Nathan Stringer - Objection to the Epping to Thornleigh Third Track

Epping to Thornleigh Third Track Proposal. Application number SSI 5132.

Figure S.6 Cross-section and elevation - New Cheltenham Station concourse building (see also S.5 for artist's impression)

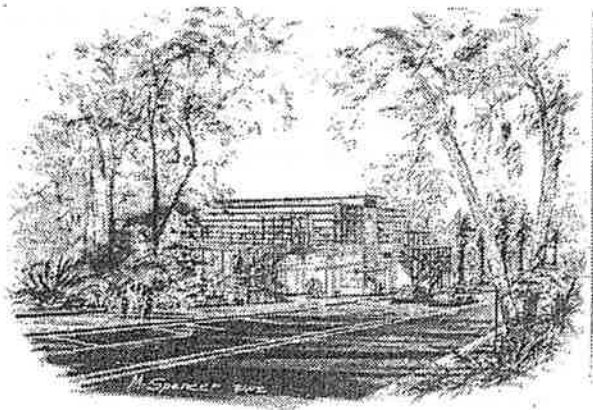
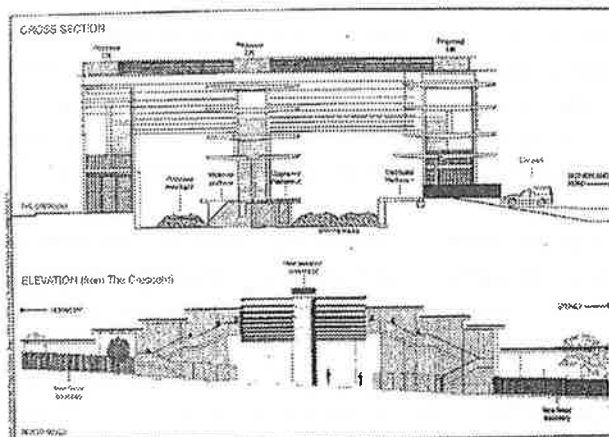
- The proposed redevelopment of Cheltenham Station shows no regard for the HCA. The visual impact of the proposed 13m high glass and steel concourse is totally unacceptable in this HCA.
